#3 Suggested Condition of Approval Included in Planning Board Report Re: 415 Cumberland
emailed to Applicant 4/23/18.

Planning Board Public Hearing 04.28.2018

415 Cumberland Avenue, Building Renovation: Commercial & Residential

**ELEVATIONS OF COMMERCIAL AREAS**

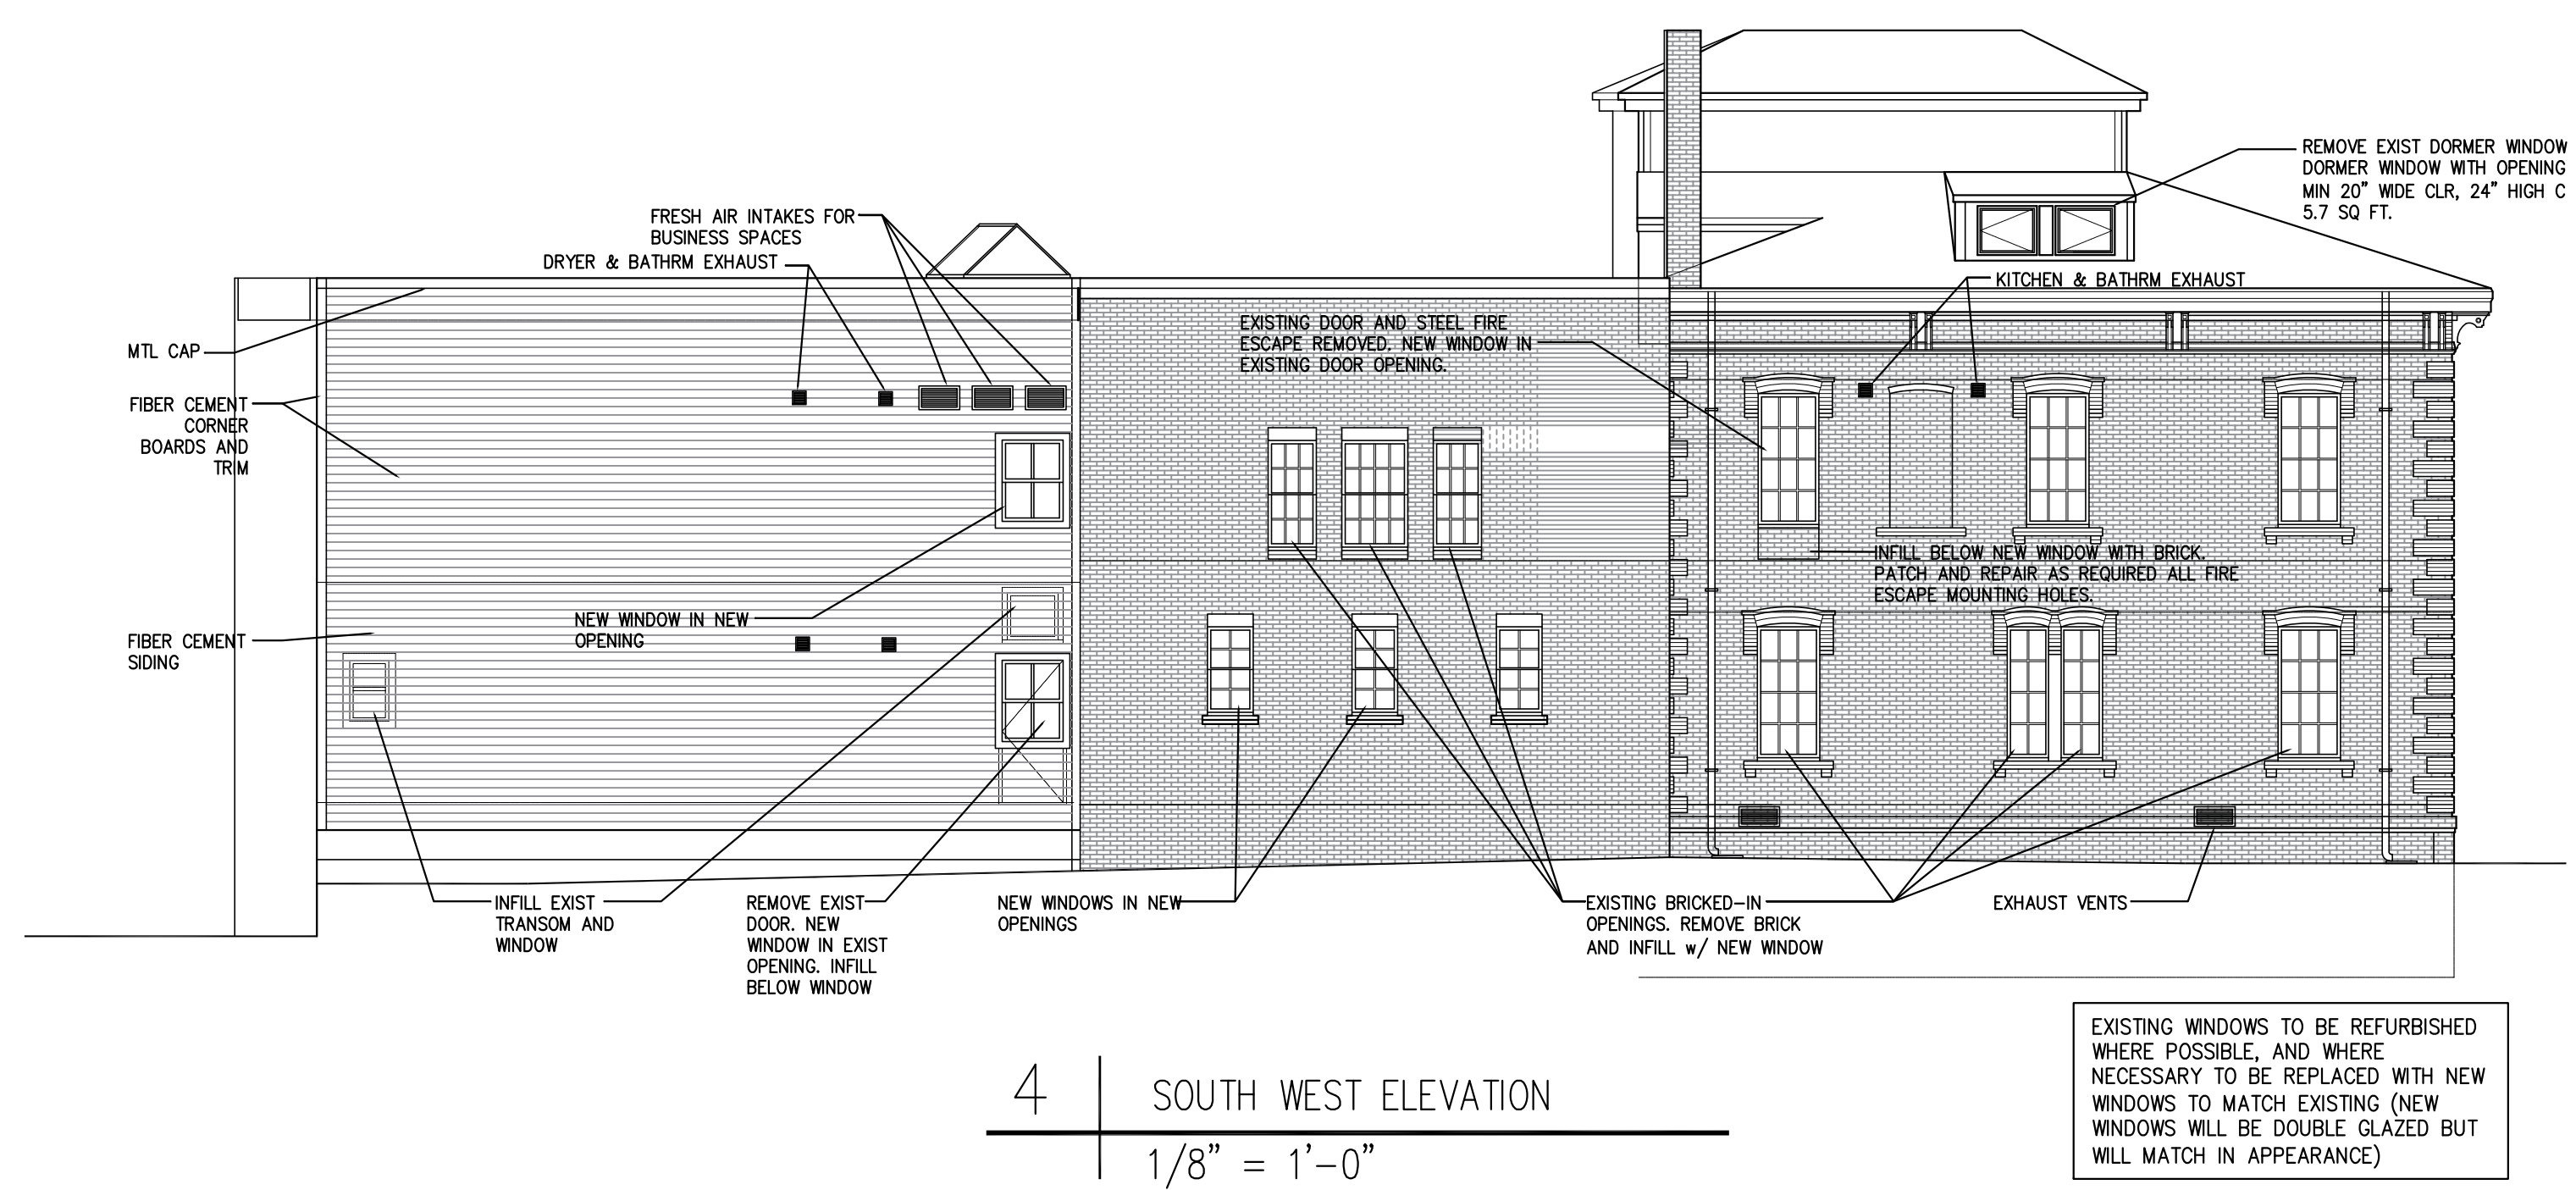
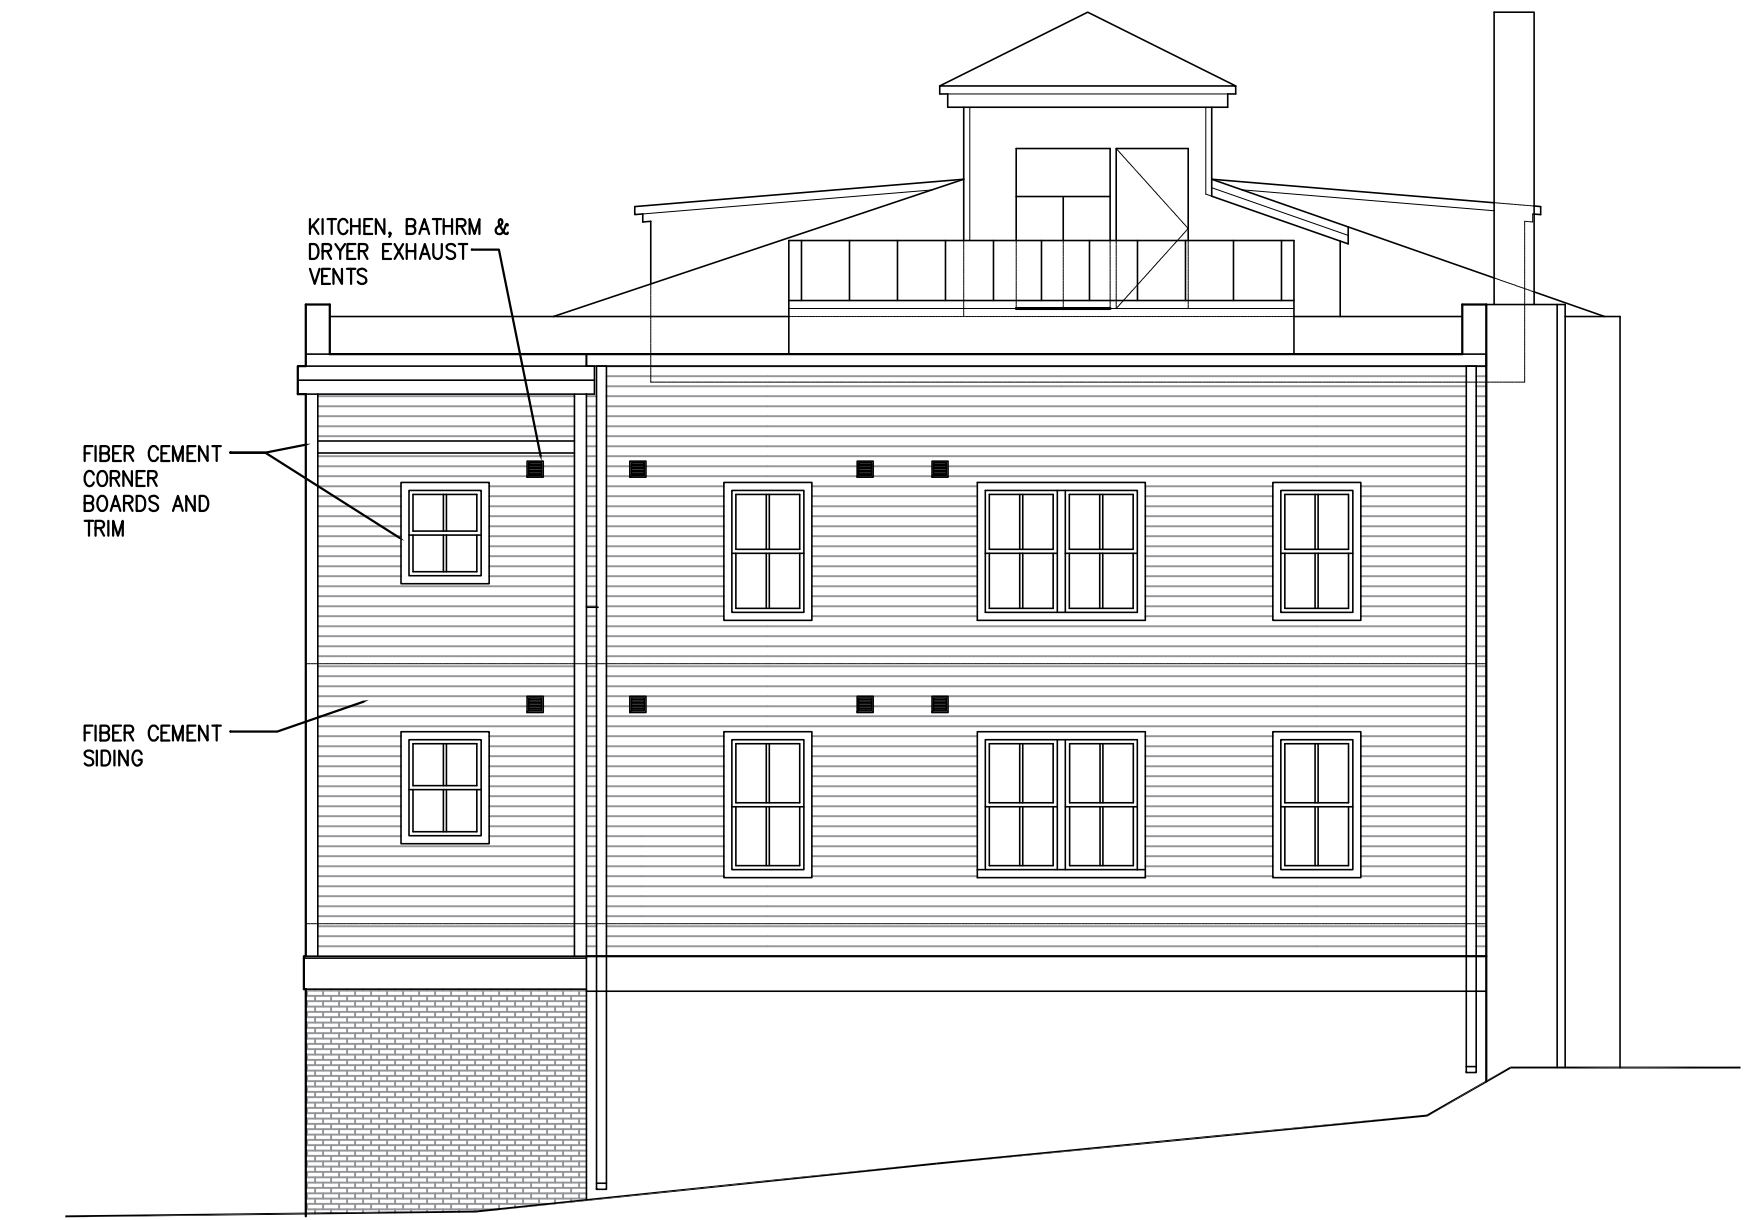
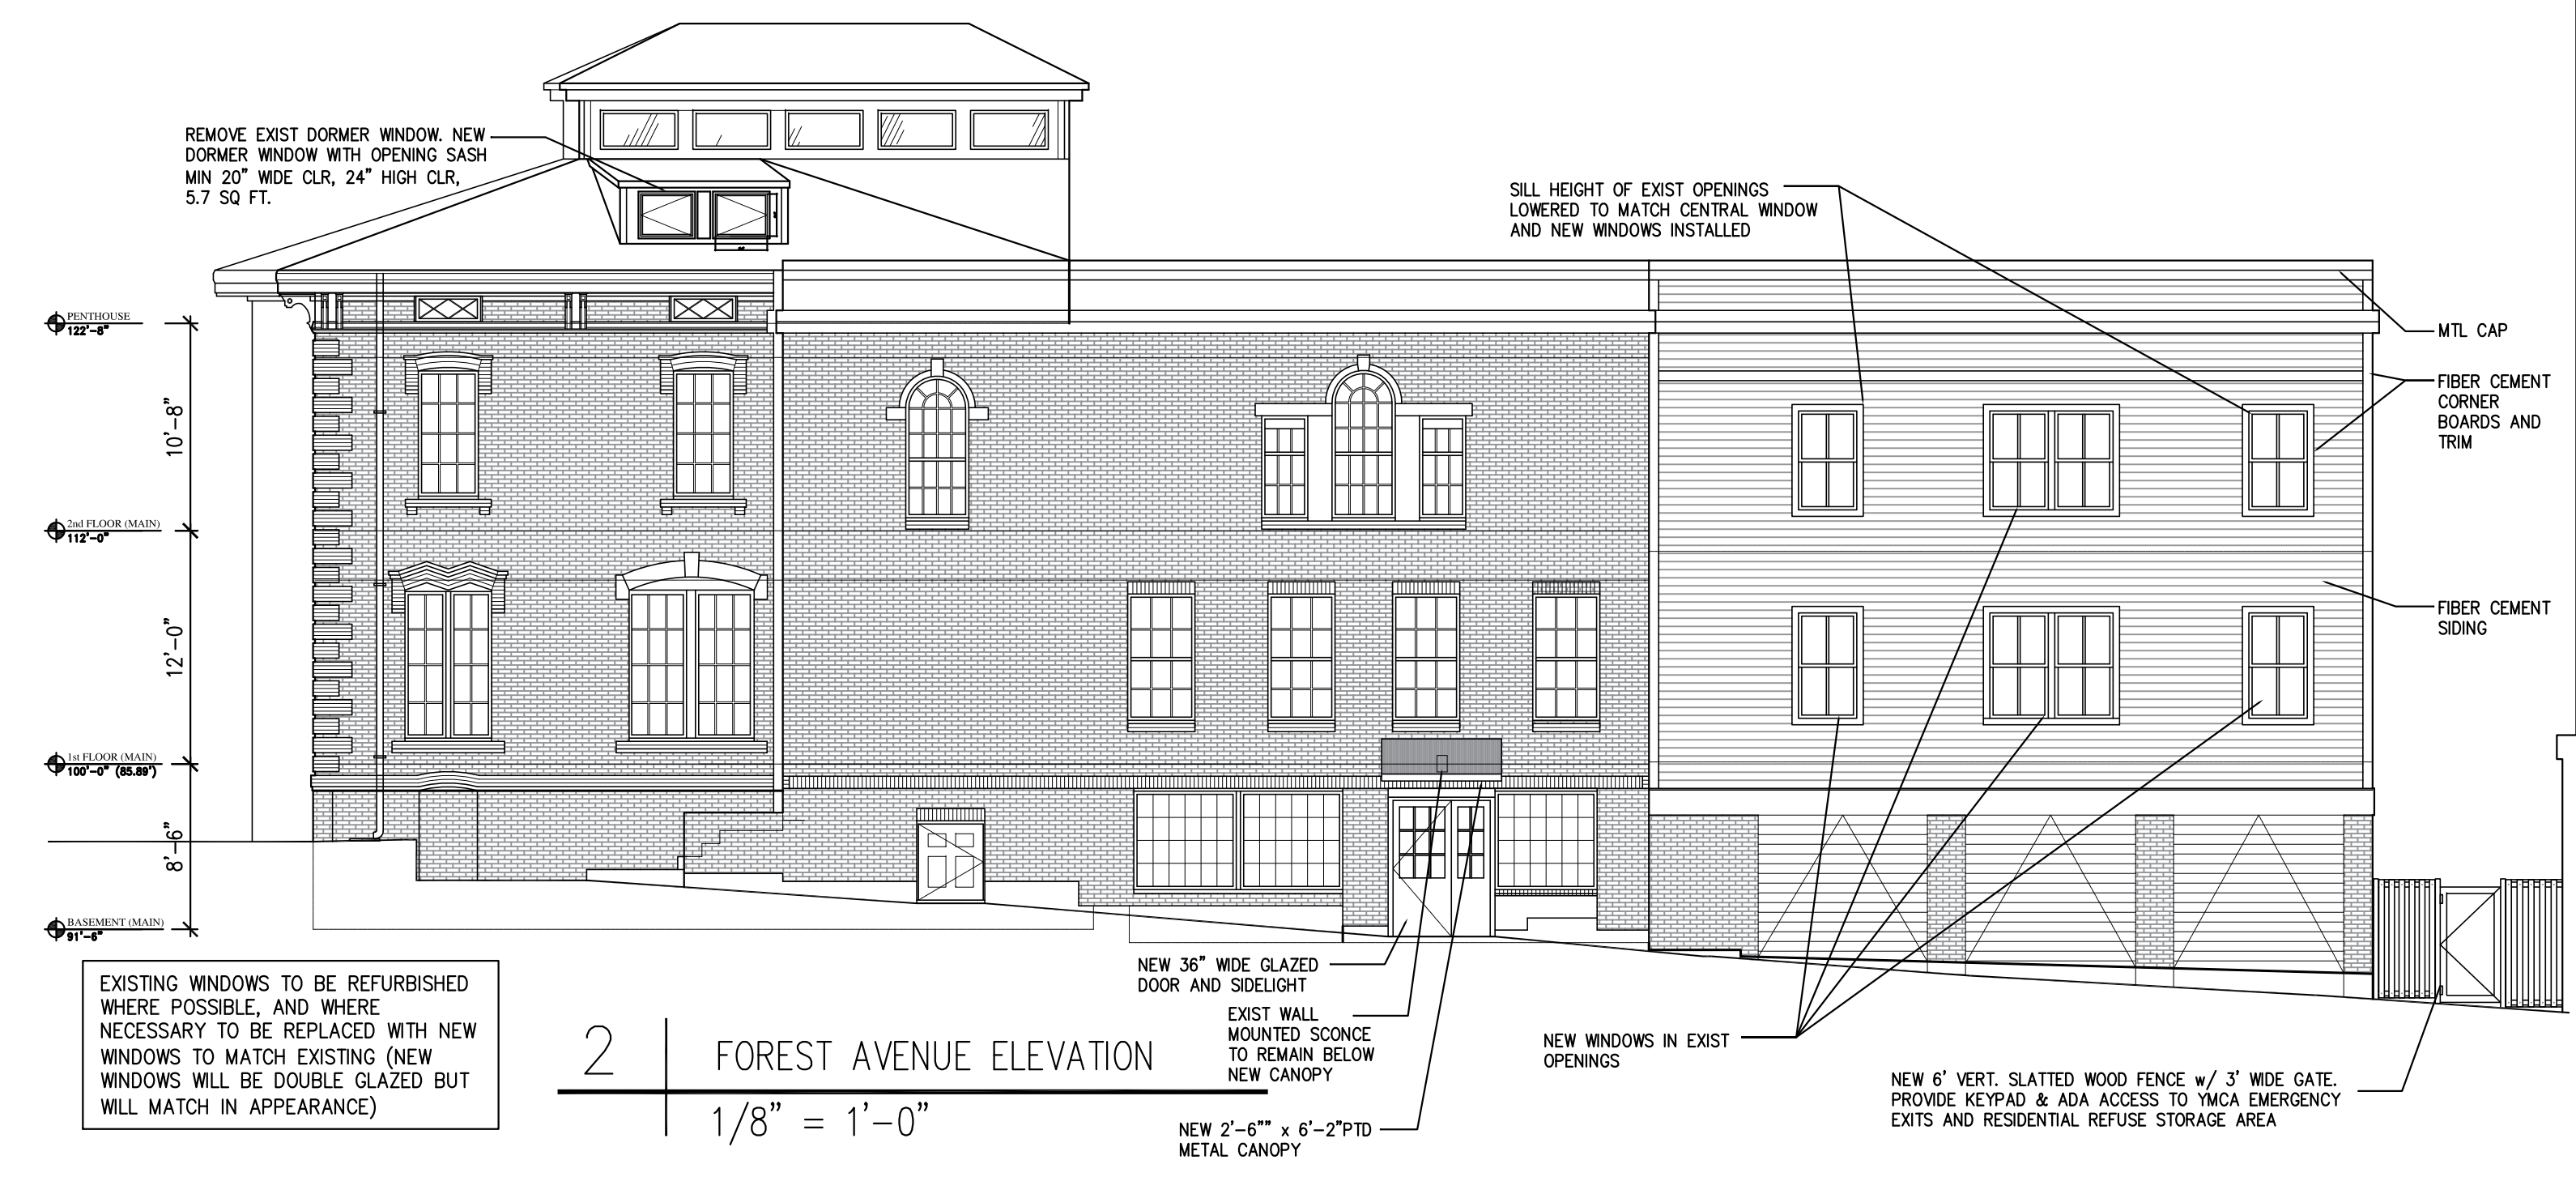
11. Please provide details on new windows. What are the materials? Windows should feature simulated divided lites with applied exterior muntins, at a minimum. Also, please identify which windows will be repaired and which will be replaced.

12. Please provide details regarding window moldings: will brick moldings be replicated in aluminum trim on other, new windows?
13. Why are two windows on the northwest elevation a different height than all other windows on that elevation and the Forest Avenue elevation? Ideally these will all match.

15. Please provide details regarding finishes. The painted finish of Hardie plank should not be high contrast, nor should the relationship of trim to the body of the building be high contrast.

16. Please specify the reveal / ttw of the Hardie plank. It should be less than 6."
17. Hardie plank shall be installed smooth side out. Please note this on plans.

18. Exhaust vents shall be painted to match the surrounding material (brick or Hardie plank siding). Please note this on plans.
19. Hardie plank at the top of the building parapets on the Forest Avenue and southwest elevations seems strange – the treatments / bands along the top of the building's middle section should be continued.

22. The coal chute on the Forest Avenue elevation shall be retained, not removed or covered. Please show this on plans.

The intent is to replace the 2nd floor windows in the brick building (residential units) and refurbish the 1st floor windows in the brick building (commercial spaces). All proposed windows in the clapboard building will be new. The revised elevations indicate which
